From: Zac Denton <Zac.Denton@arun.gov.uk>
Sent: 12 November 2020 12:32
To: Planning.Responses <Planning.Responses@arun.gov.uk>
Subject: FW: EP/124/20/HH Little Dormers 23 Upper Drive BN16 1QN - Objection

From: Stephen Milliner [REDACTED]
Sent: 12 November 2020 11:39
To: Zac Denton <Zac.Denton@arun.gov.uk>; Planning <Planning@arun.gov.uk>
Subject: EP/124/20/HH Little Dormers 23 Upper Drive BN16 1QN - Objection

Location Plan and Block Plan

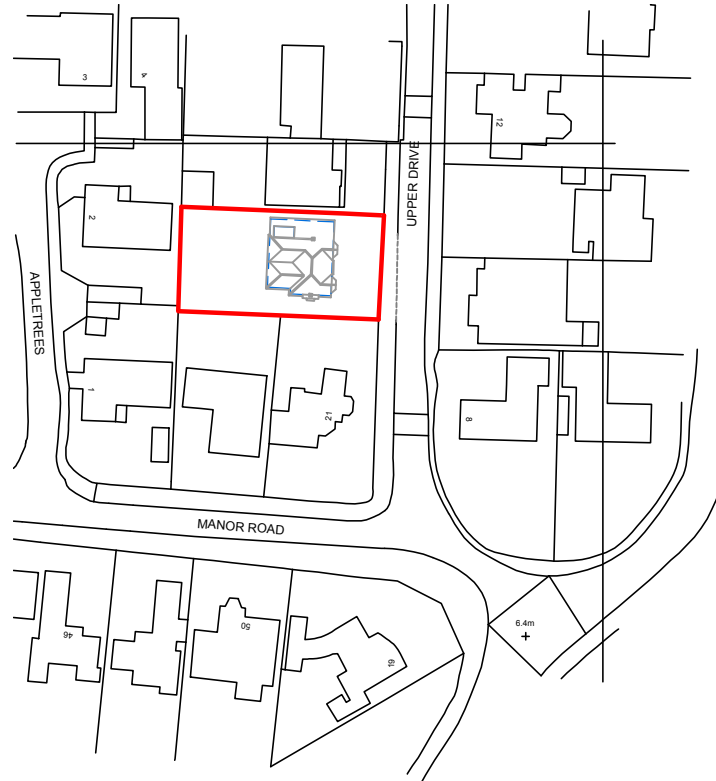
The positioning of the red line on an application for planning is amended from that previously shown on application EP/99/20/HH and now in the correct location. There is works to the east of the development boundary shown on the drawing and whilst making the AOSERA verge green as originally intended on the

estate is welcomed it should not be considered in the application decision as any works are outside the application defined by the red line.

The boundary fence is shown as being 1.8m height right up to the front/east boundary of the property which affects the visual amenity. It would be better if such a fence was set back from the adjacent land ownership/frontage or reduced in height at the front of the development to say 1m and remain no higher in perpetuity.

That the materials and style/arrangement of the north boundary fence shown on the application be submitted and approved by the Council and that any fence on the north side of the development should remain in perpetuity and in the style/arrangement approved by the Council to prevent further derogation of the visual amenity and possible wind issues to the adjacent property.

Floor Plans and Roof Plan - Existing

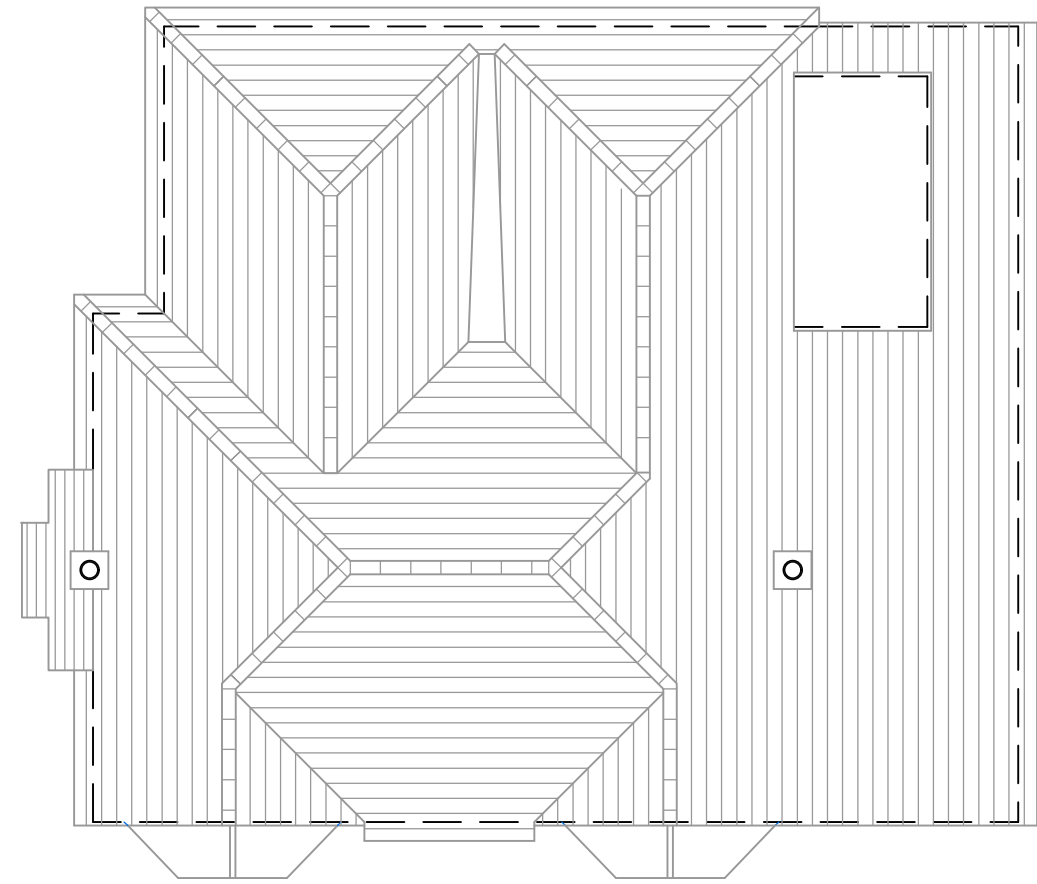
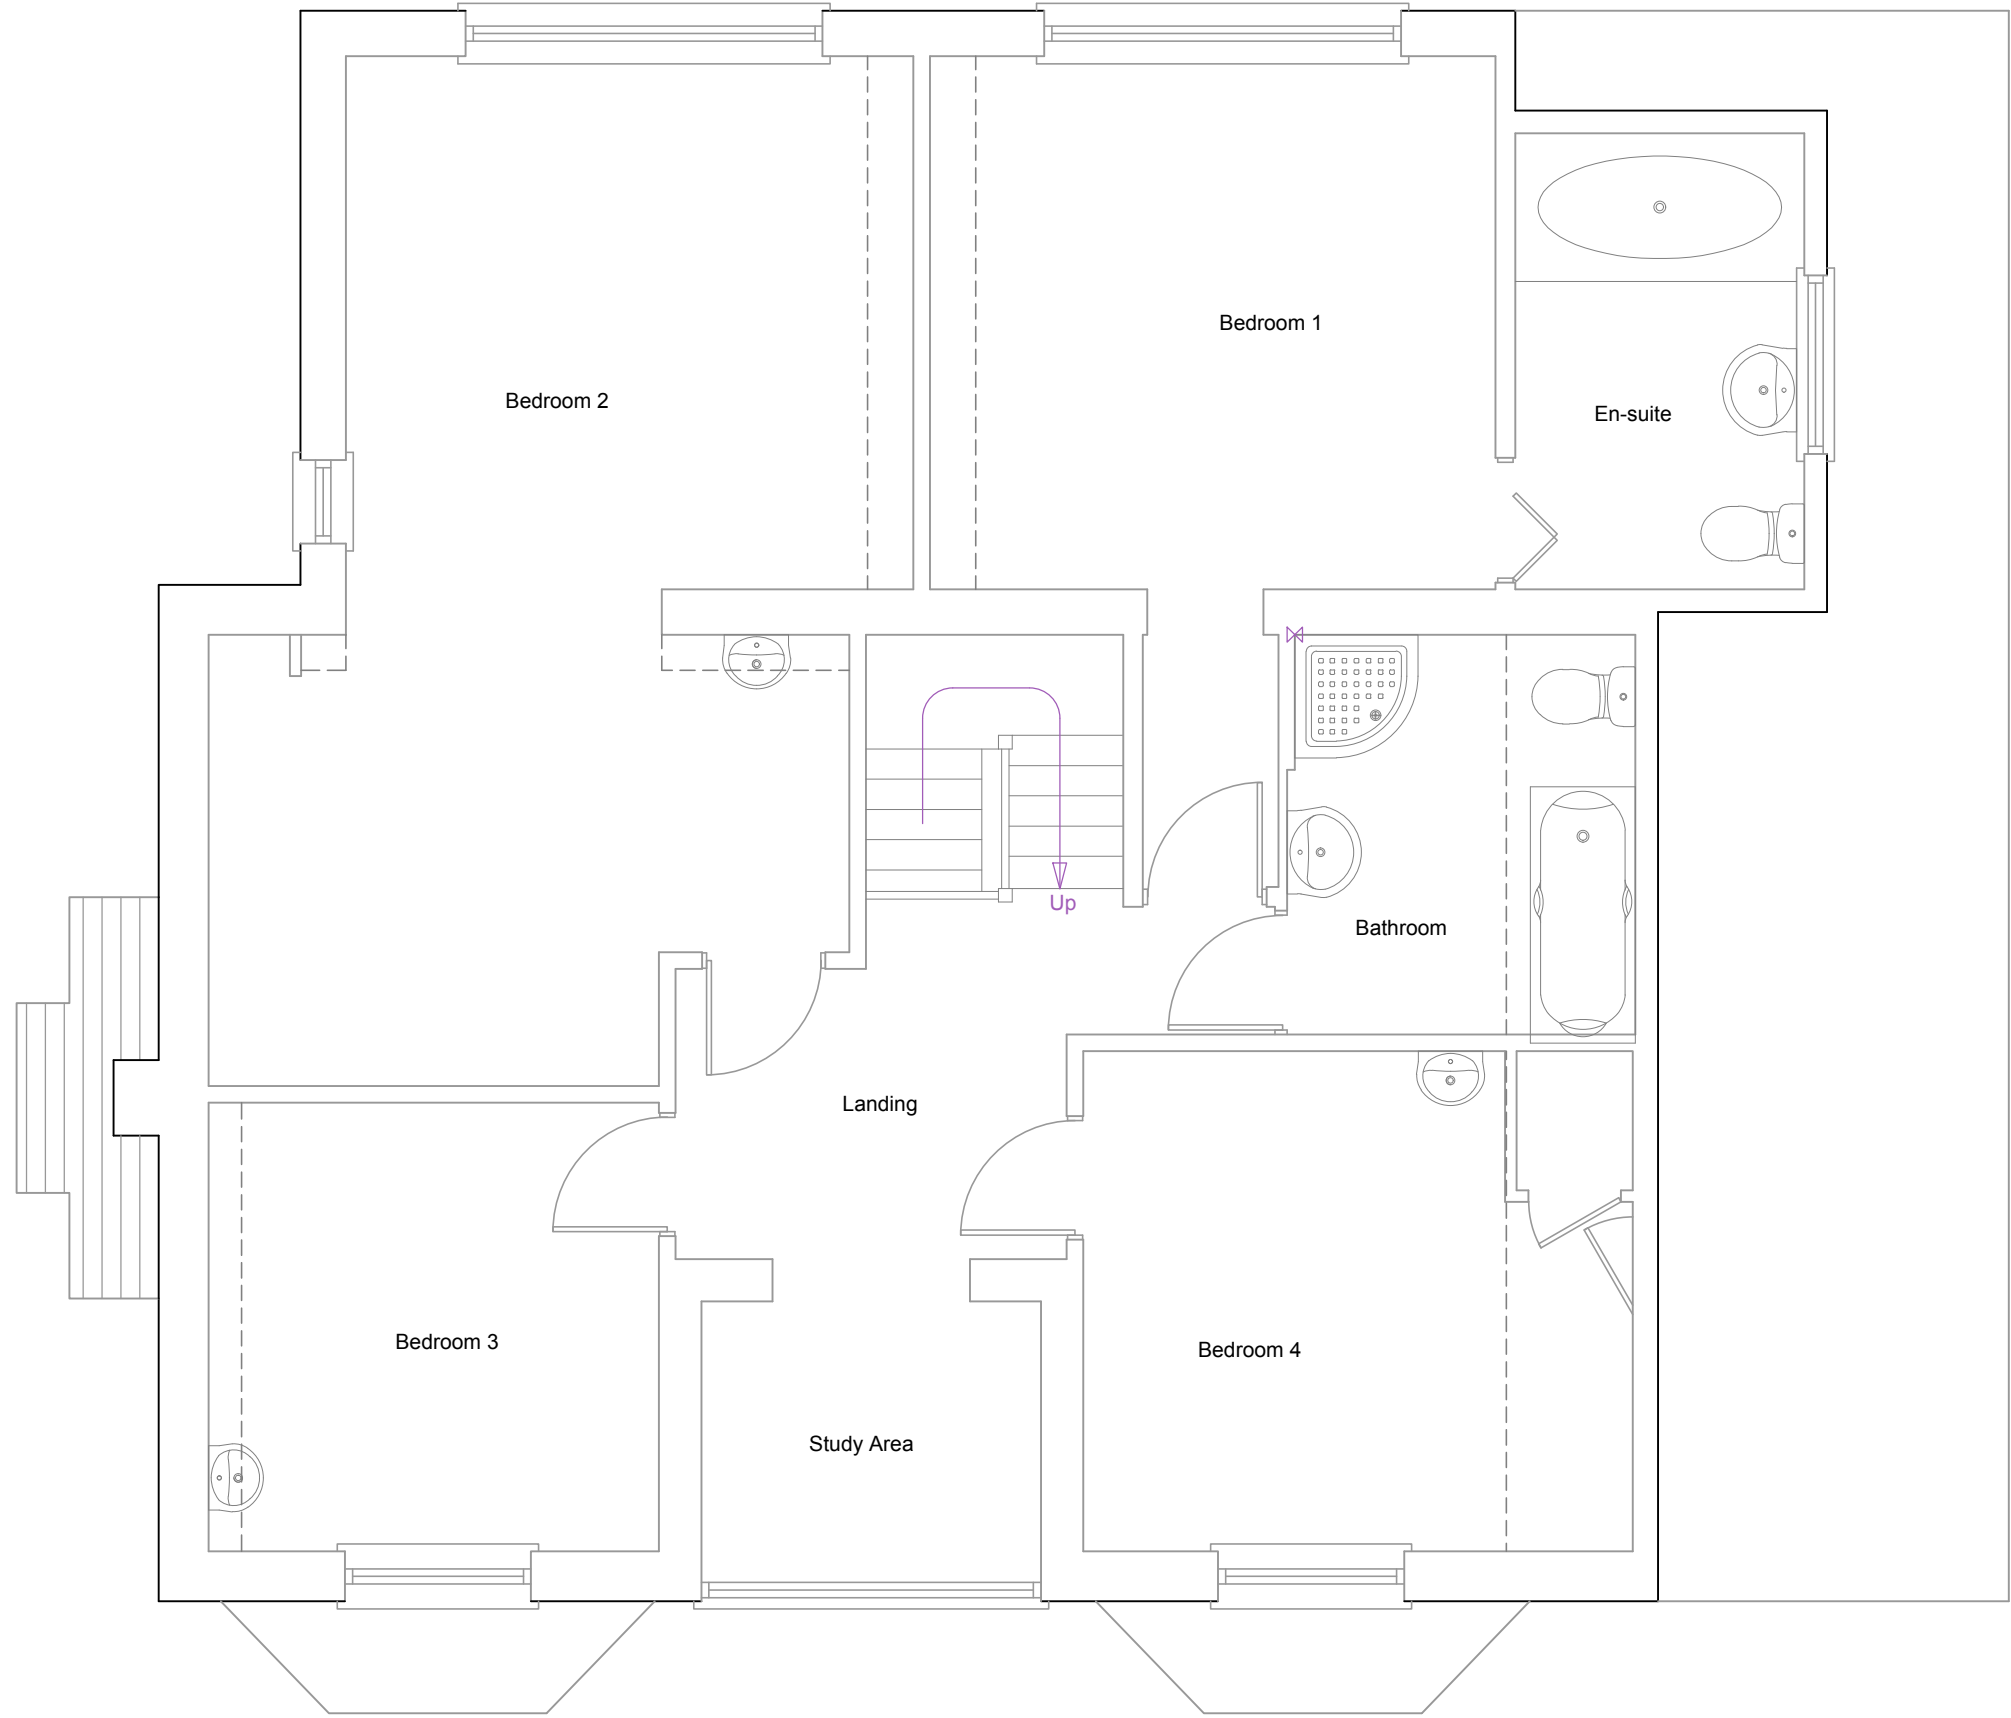
The applicant has still defined the space at the very north east of the existing dwelling on the plan submitted as a dining room. This is not the case and the space is a garage. I enclose photographic evidence to confirm this and I believe the existing elevation on the application shows the garage door.

Drawing Name
Elevations-
Proposed

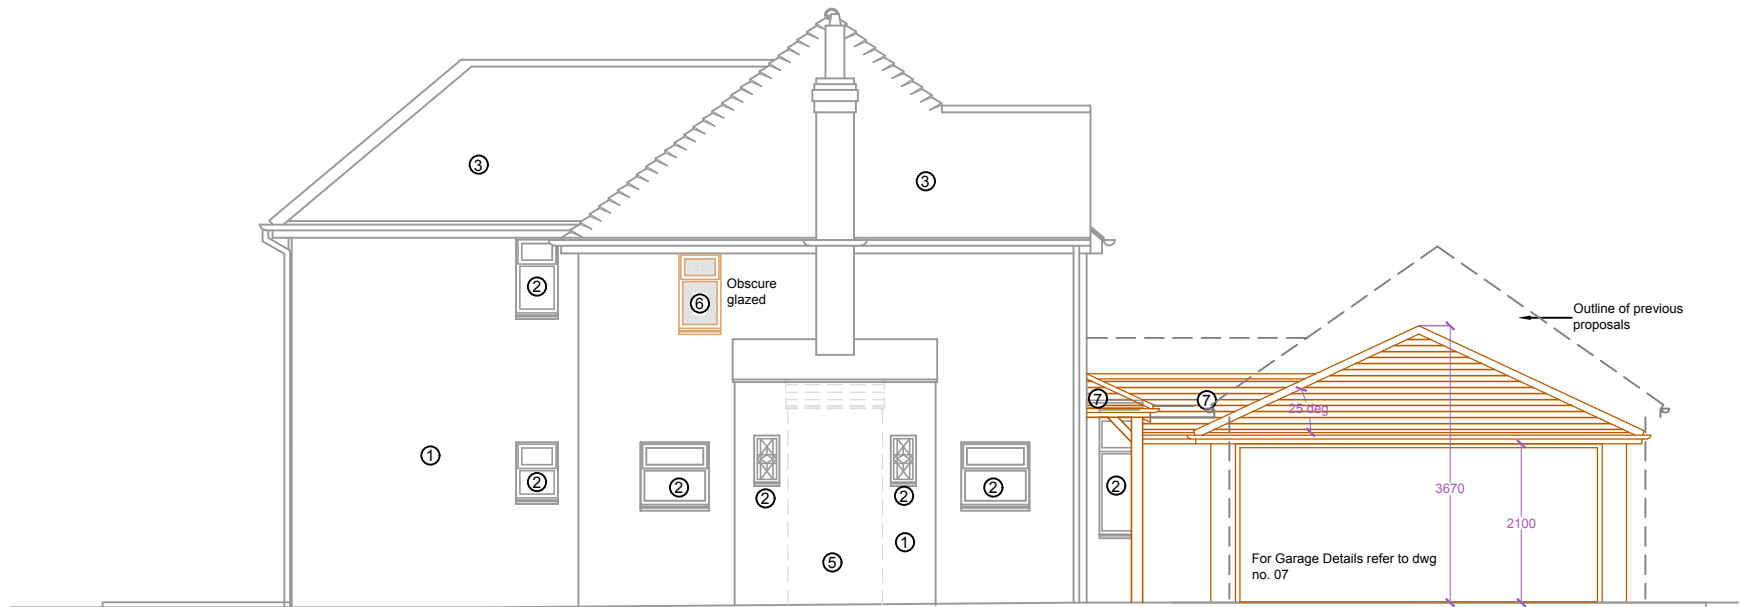
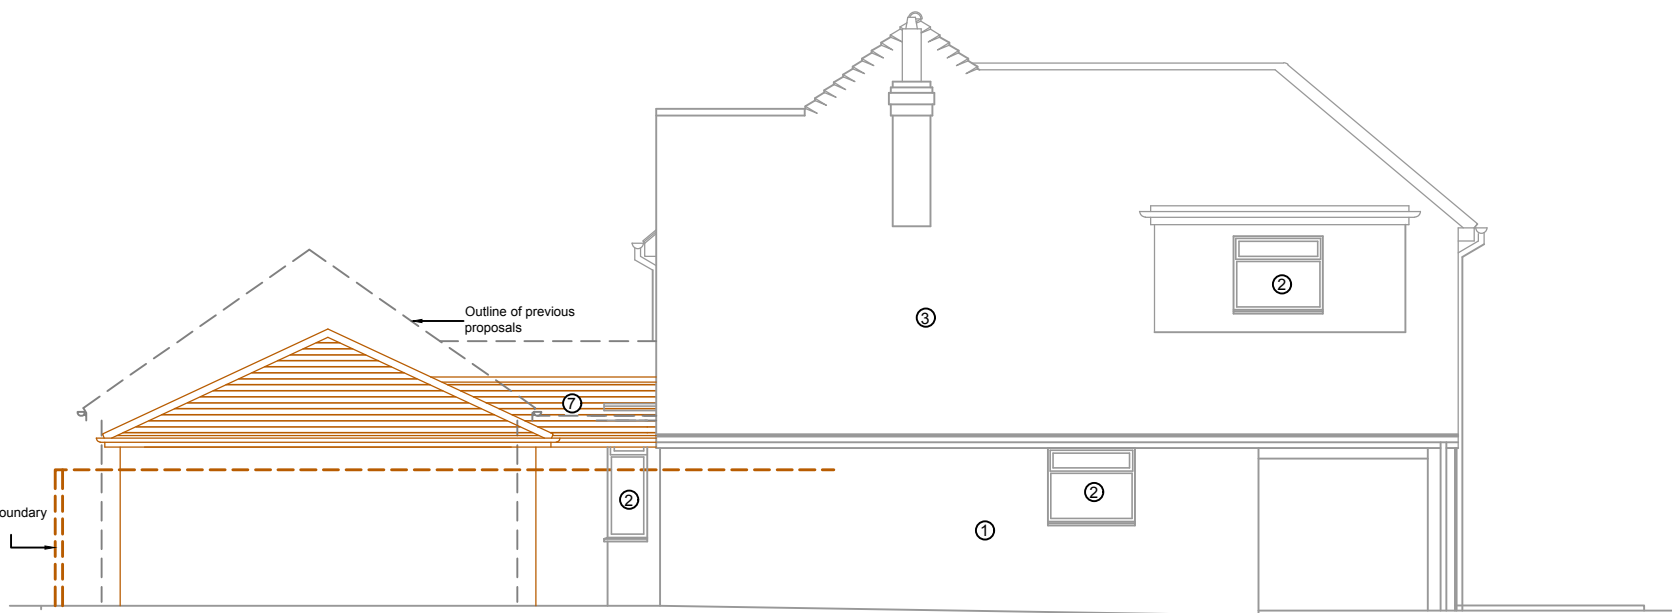
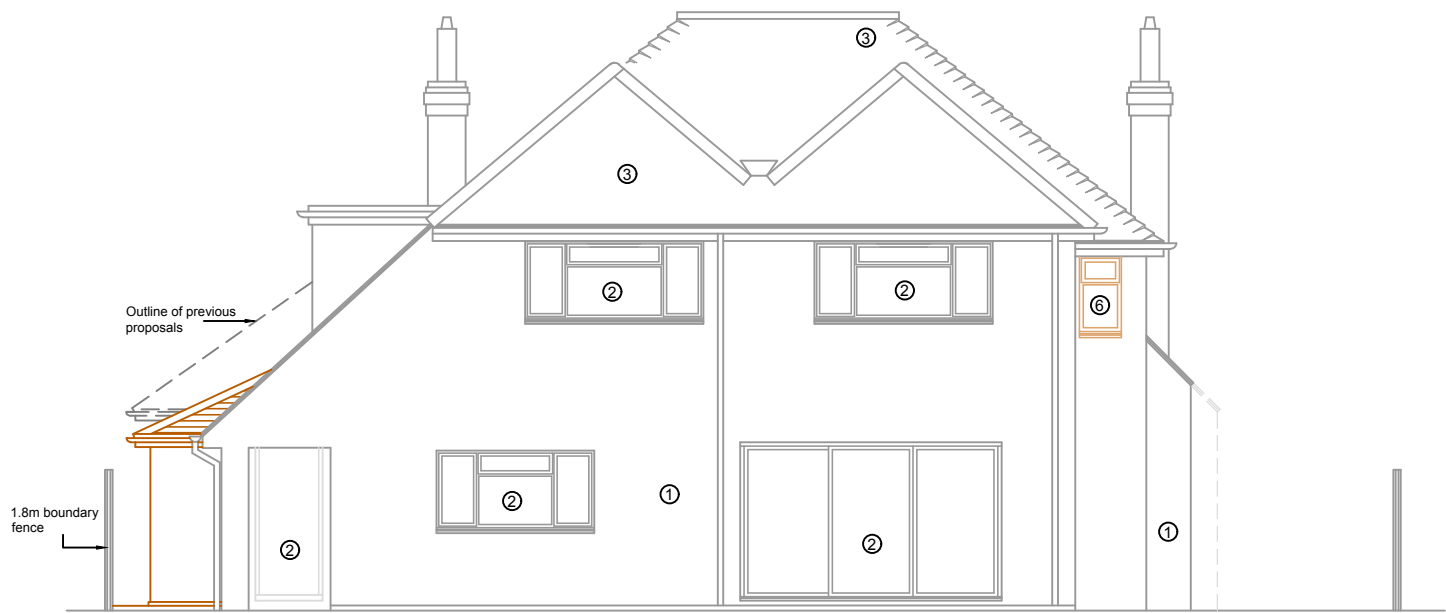
What is proposed at the front of the property will result in a horrendous street view with a blank flank wall immediately adjacent to the highway road/verge together with the remaining significant roof massing above. Upper Drive is an eclectic mixture of residential buildings, generally low in height plus set back from the highway and the proposal significantly derogates the existing visual amenity.

There is a new window proposed at first floor on the south elevation within bedroom 2 which may cause overlooking issues to the dwelling to the south of the development (21 Upper Drive). The applicant has now shown obscure glass but also shows an opening window. The height of the opening window above the internal finish floor level is not defined and as such overlooking prevention is not confirmed on the drawing. This is in conflict with policy D DM4 although should be easily resolved by a condition.

That the overlooking issue is dealt with in a manner consistent with other planning applications and obscure glass plus non opening windows below a height of 1.8m from FFL are adopted to prevent such overlooking and be provided in perpetuity.
